Arborist Response

**Re: Royal Hall of Industries
Lot 3, (D.P.861843) and Lot 52 (D.P.1041134)
No. 1 Driver Avenue, MOORE PARK**

The following document provides a response to the request for additional information¹ regarding the application for the 'Adaptive reuse of the Royal Hall of Industries' (SSD-9726)¹. This document is based on the data provided in the Arboricultural Impact Assessment (referenced D3355, Date: May 2019) and related Addendum (referenced D3355A, Date: 18th October 2019). This response addresses Section 7 and 7.1 from the council document¹ and cites each Section and the response.

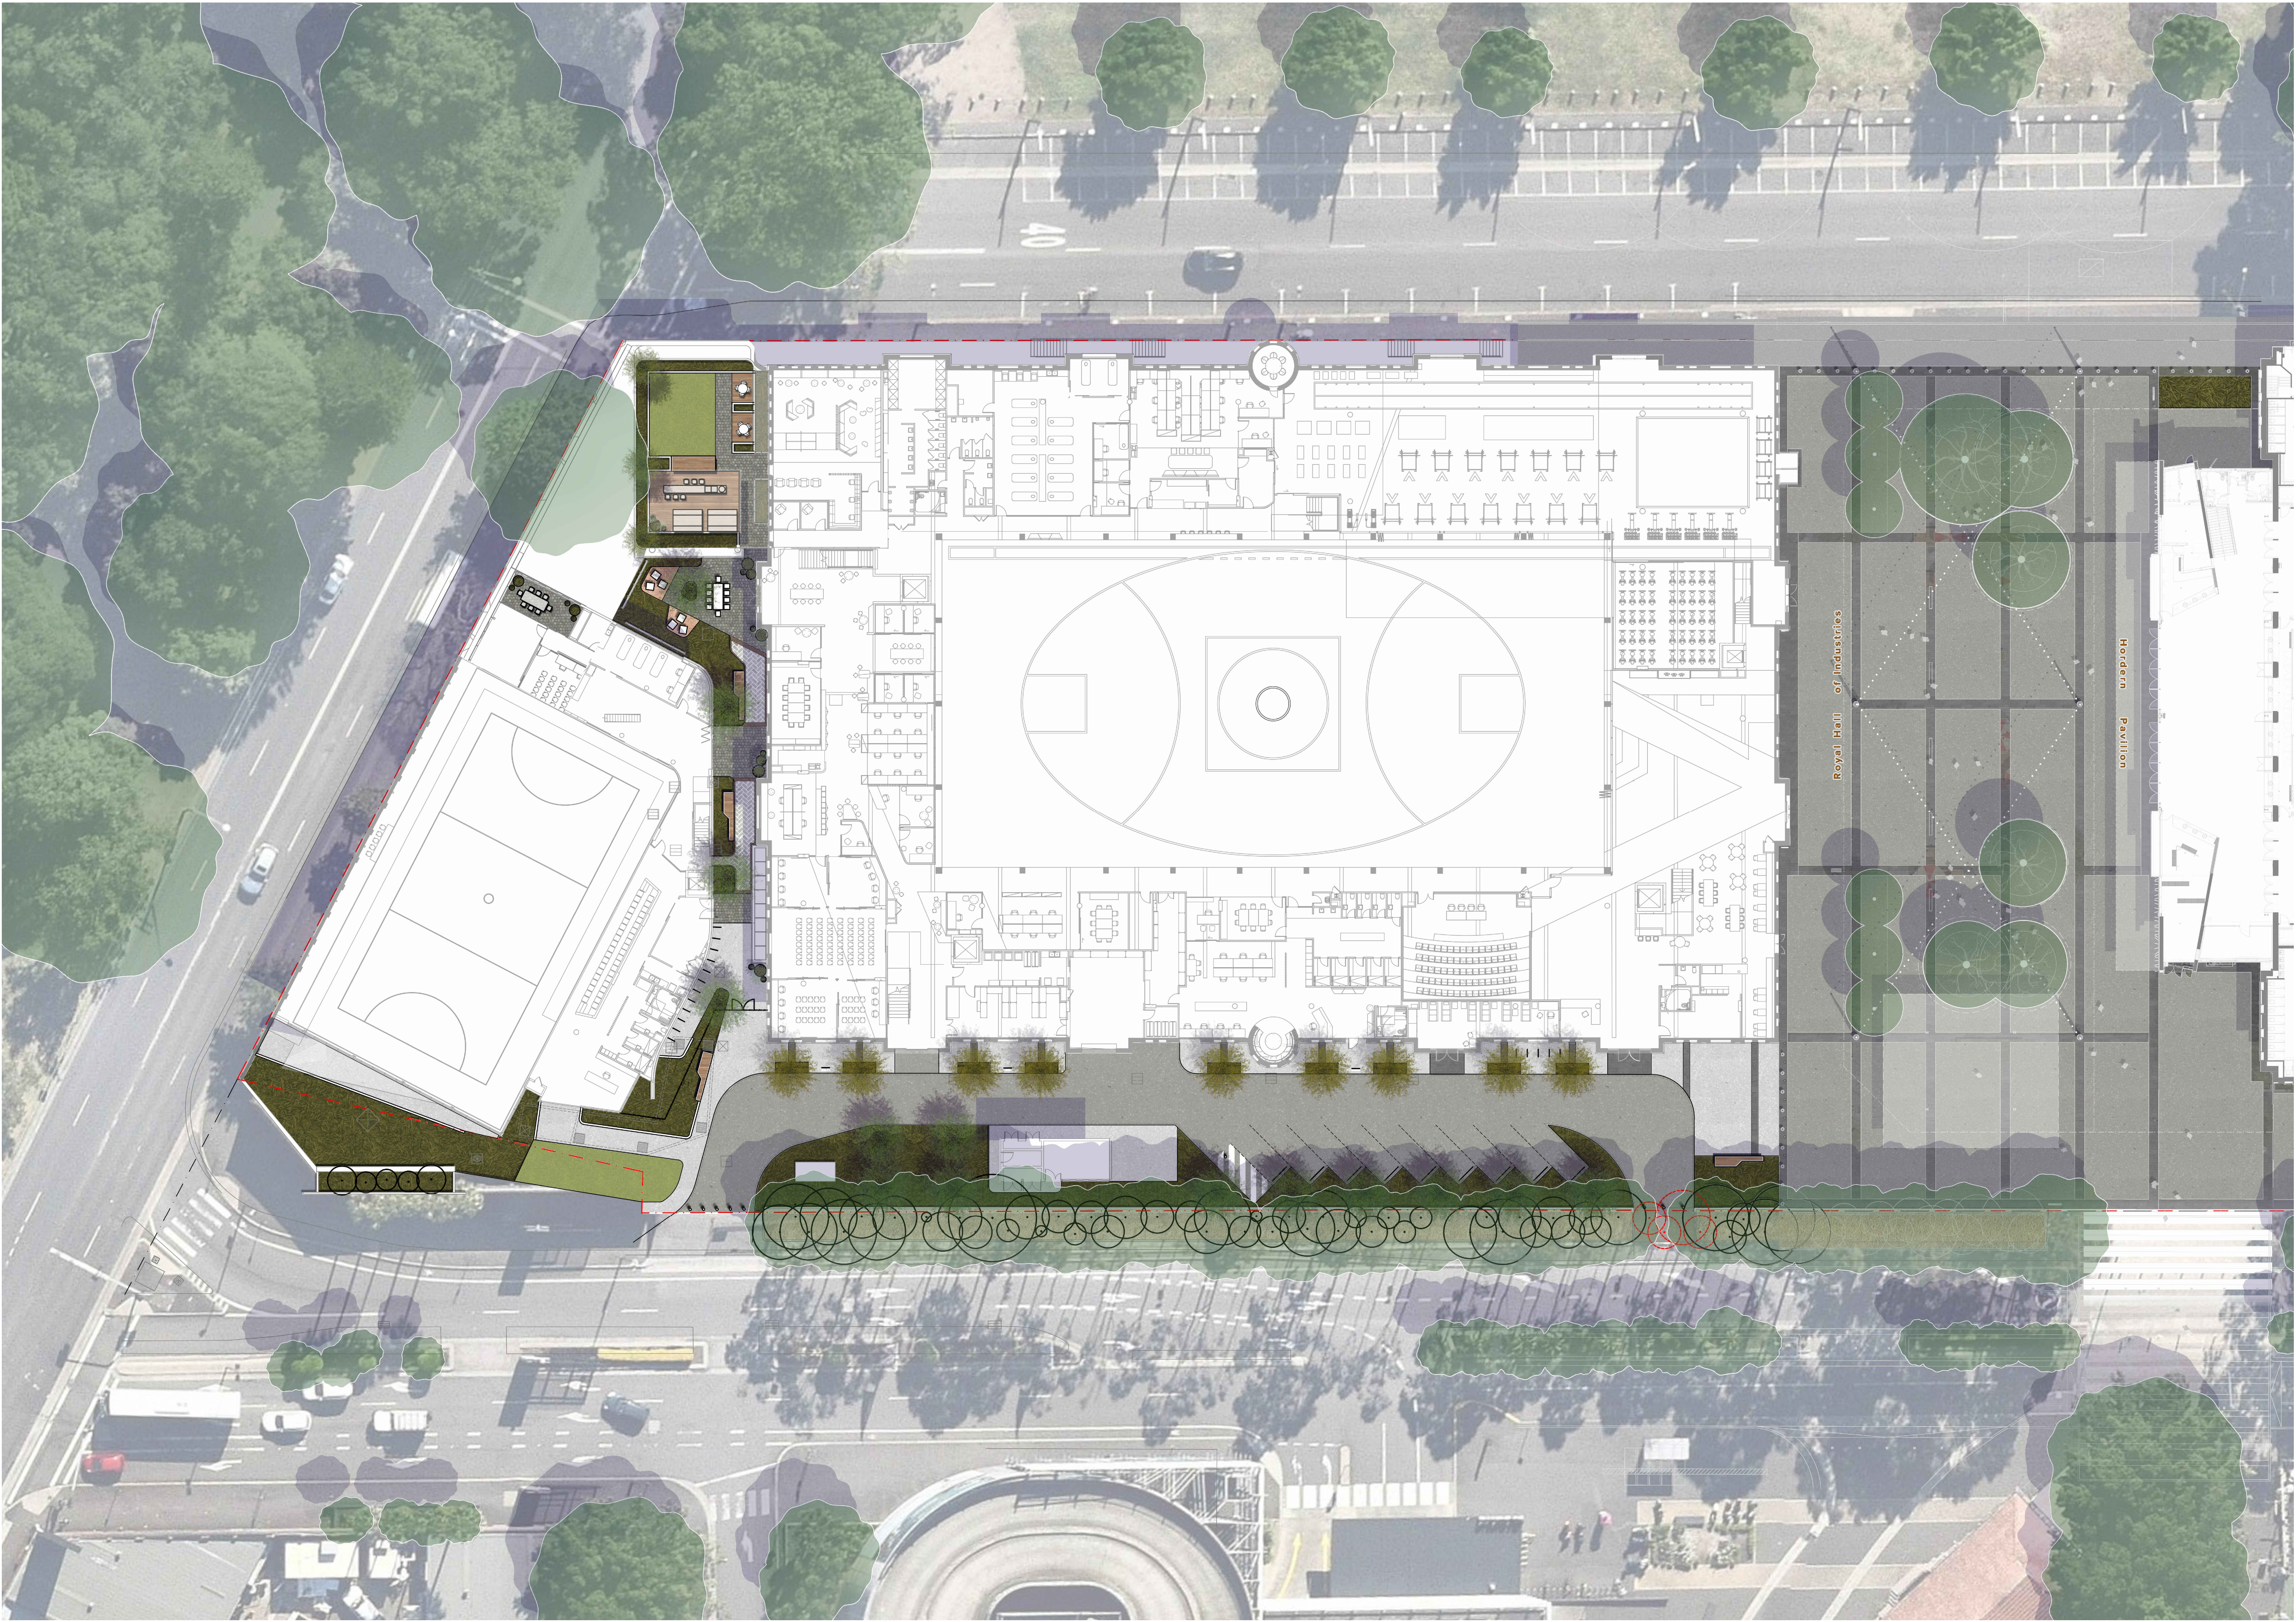
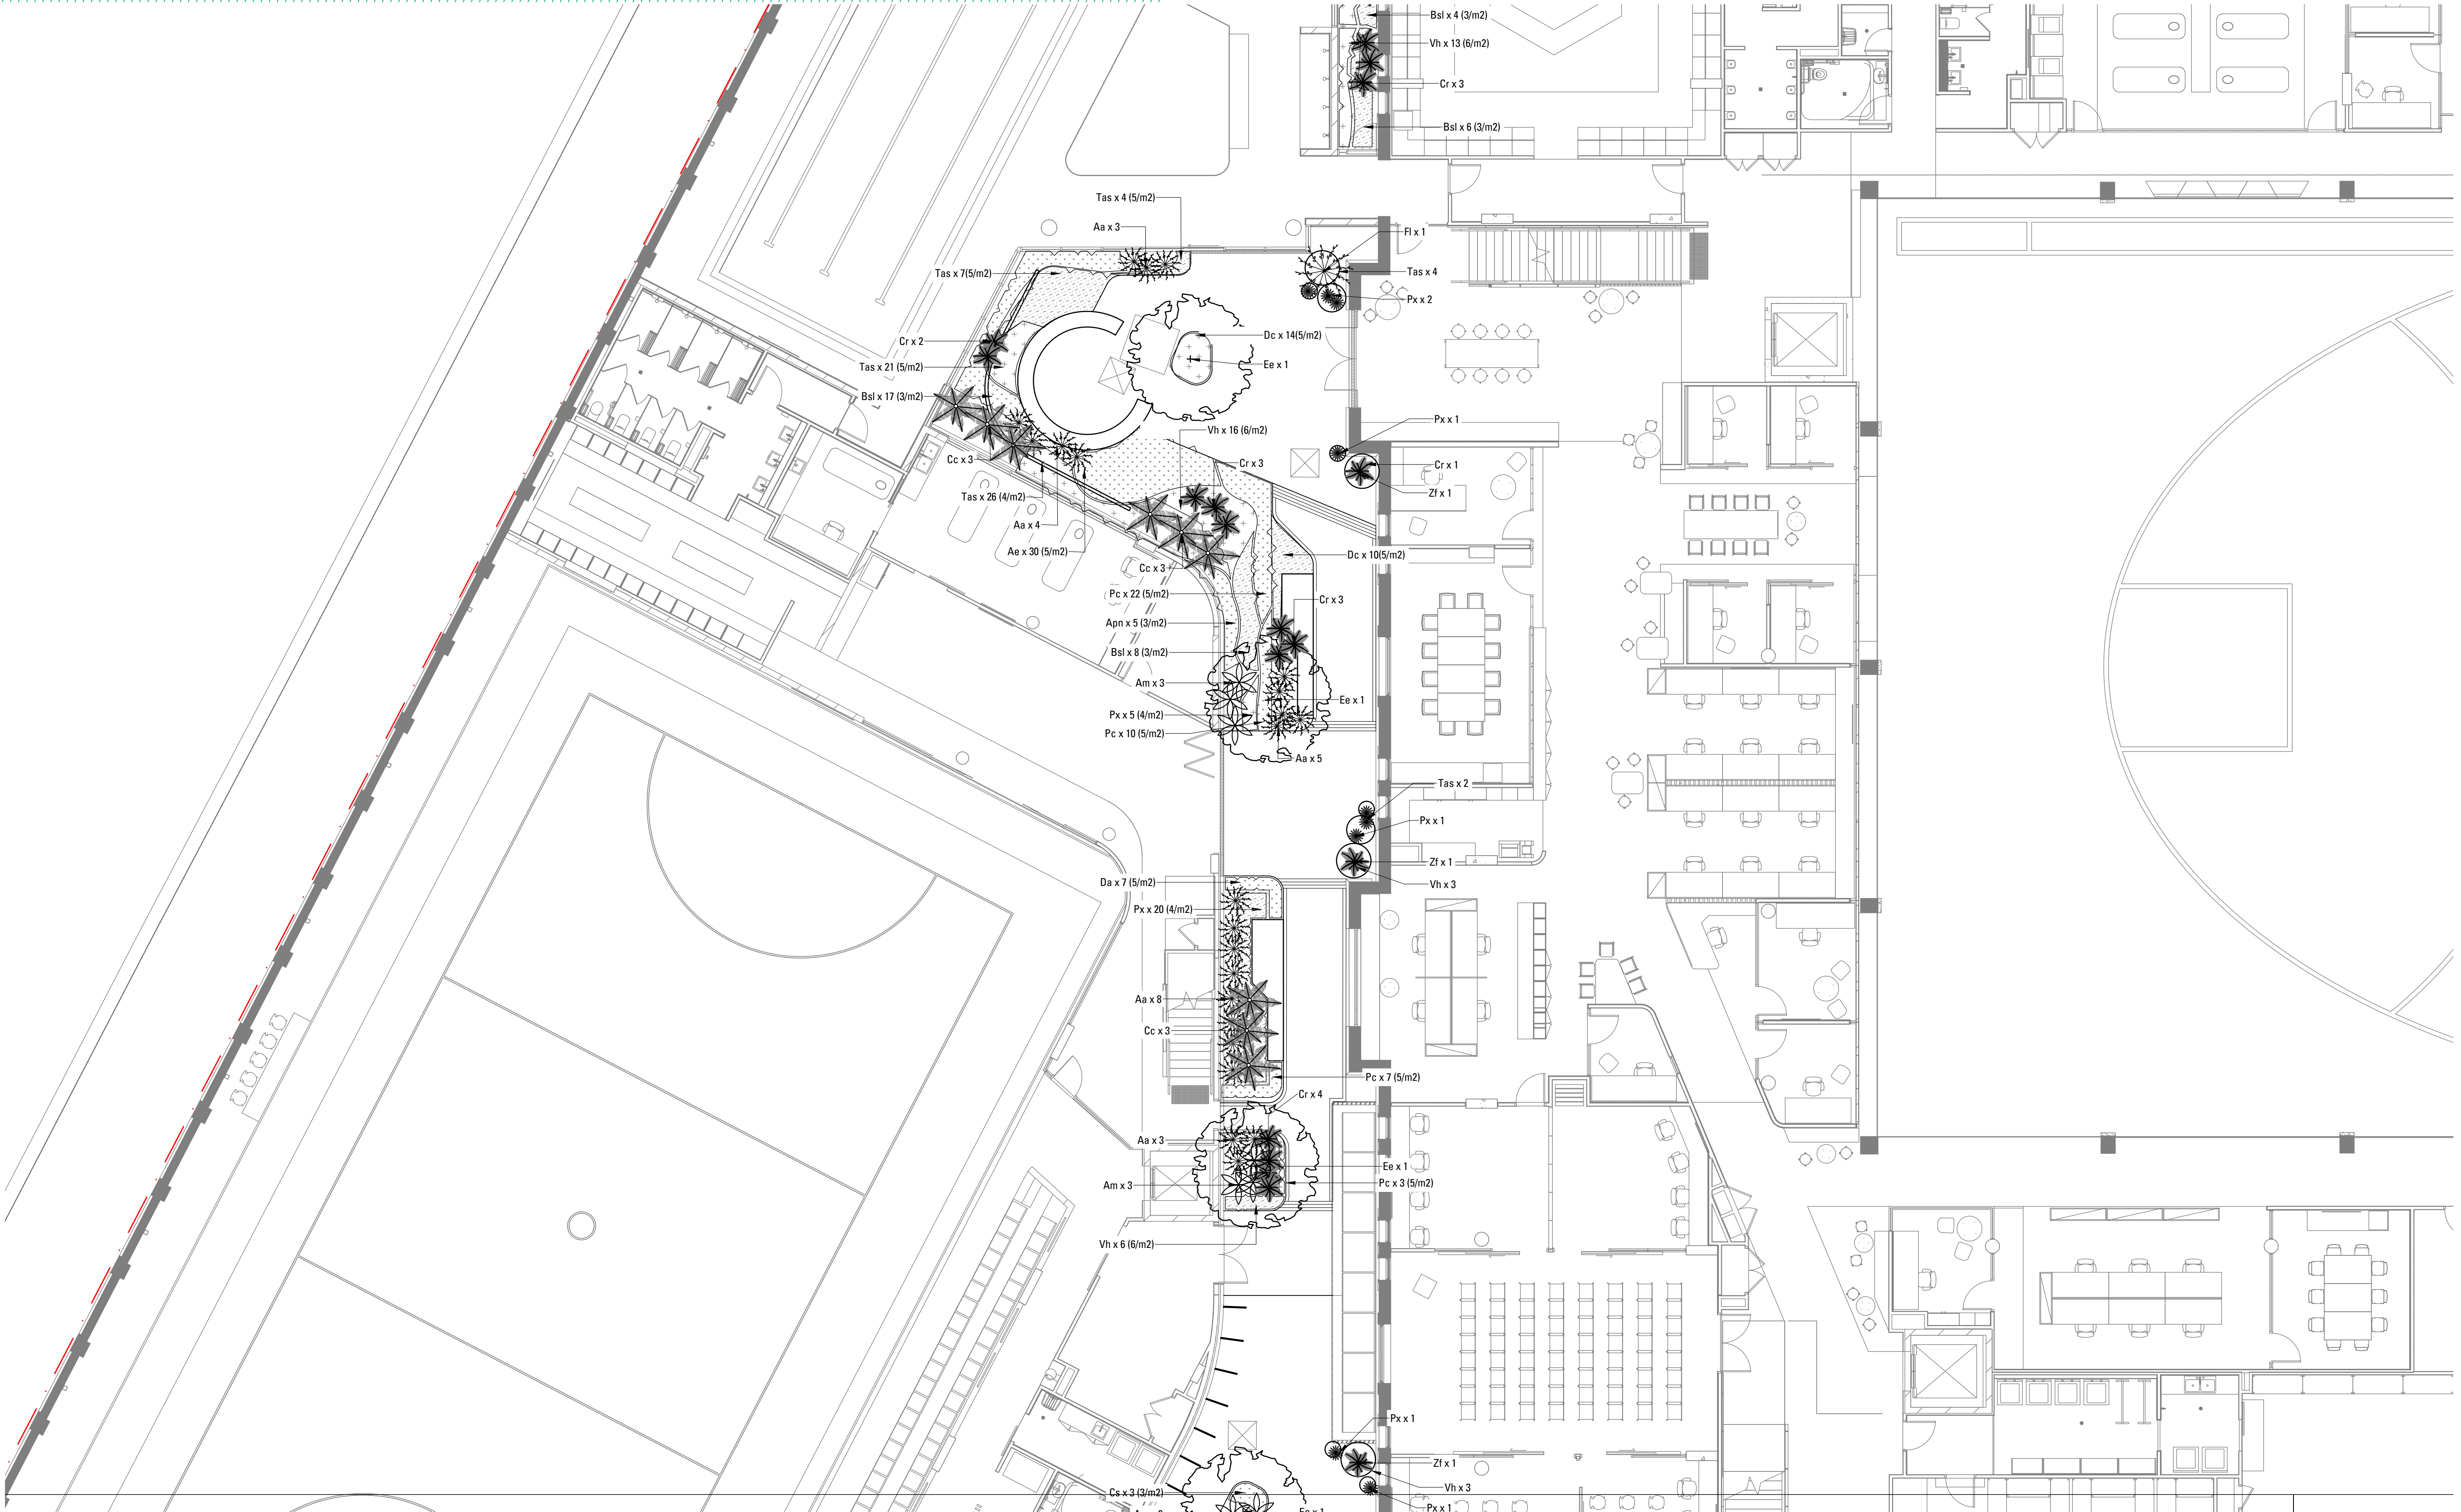
- e) *The Landscape Details indicate trees are planted into 'structural vaults'. The landscape plans do not clearly show where these vaults will be located*

This has been included in the Landscape drawing by *Arcadia*, January 2020, Issue G.
